# CITY OF ALBUQUERQUE

July 18, 2016

**Re: Signal Pointe  
Request for Pad Certification - Not Accepted  
Engineer's Stamp Date 9-15-15 (C20D070)  
Certification date: 7-15-16**

LOTS 19 & 20, BLK. 4, TRACT 3, UNIT 3
NORTH ALBUQU. ACRES, ALBUQUERQUE, NEW MEXICO
SIGNAL AVENUE SUBDIVISION
Grading & Drainage Plan
DESIGNED BY: PWC
CHECKED BY: PWC
DATE: 2/28/15
JOB #: SignalPointe
SHEET: 1 OF 1

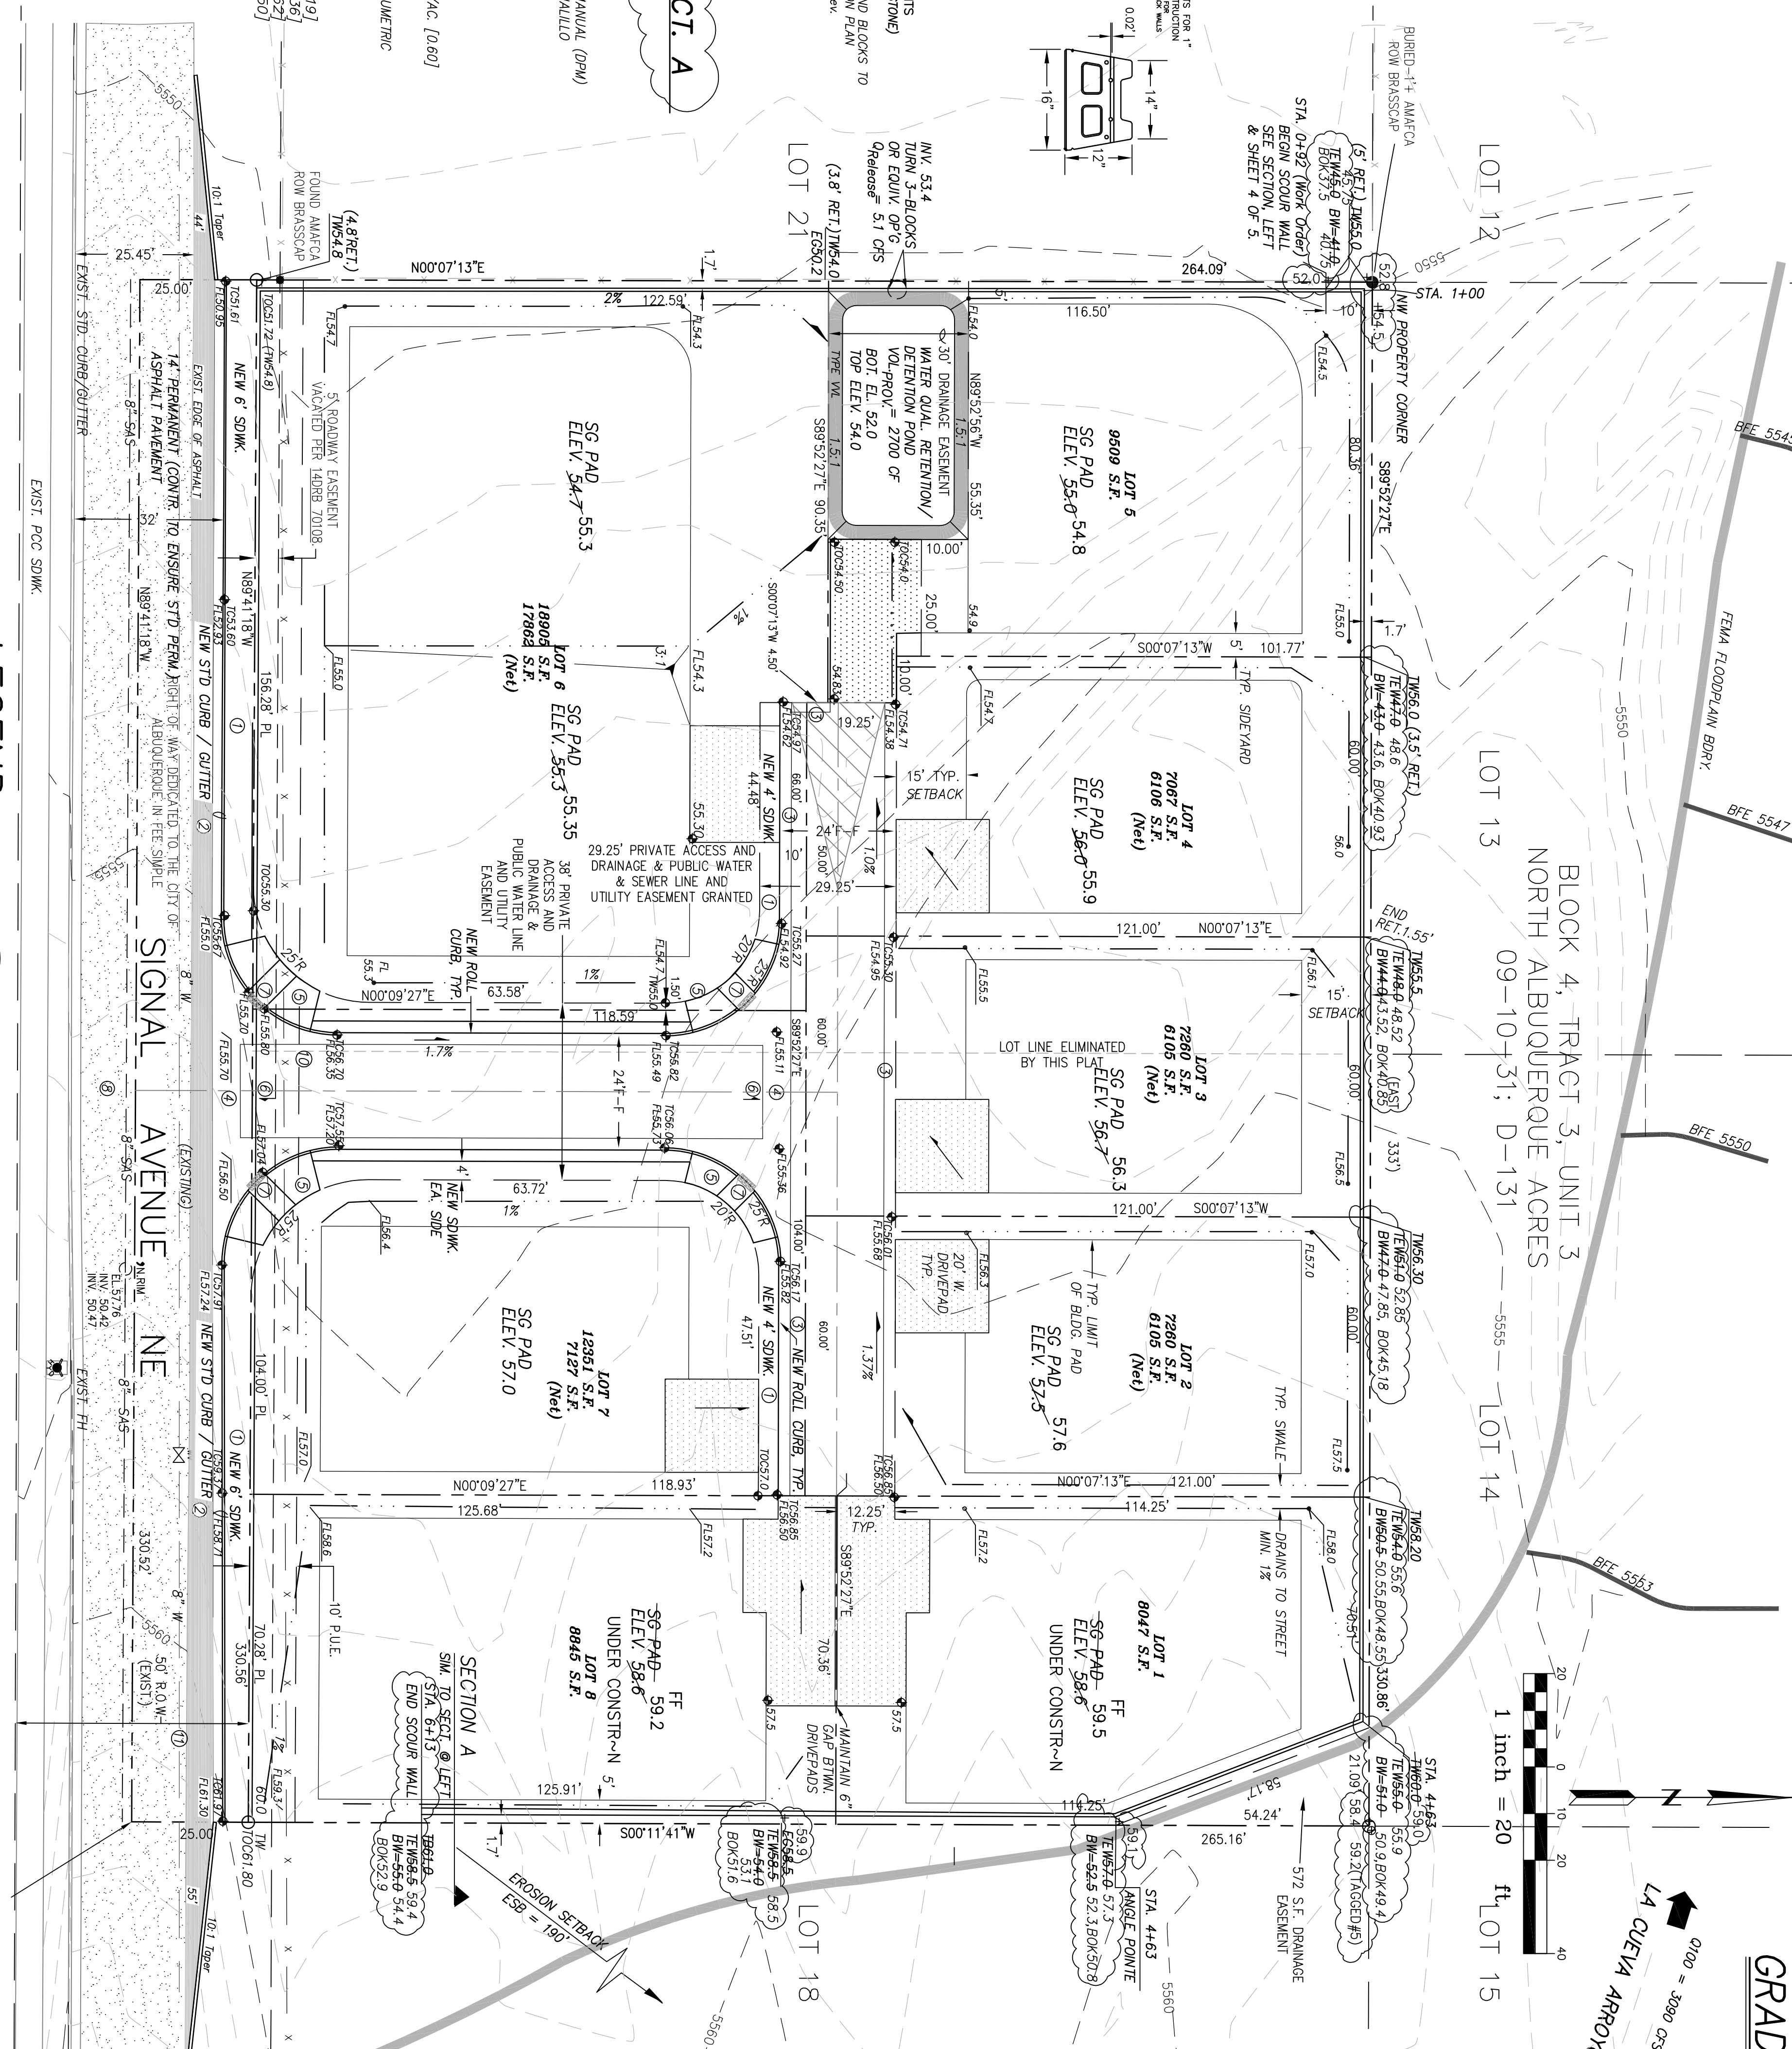
1. Provide spot elevations around all pads.
2. Provide finish grade elevations on both sides of scour wall. There appears to be additional fill along the outer wall not accounted for.
3. Show permission to disturb the grades from property owners north and east of Signal Pointe subdivision limits.
4. Reseed disturbed areas outside of Signal Pointe subdivision as to restore to original condition.
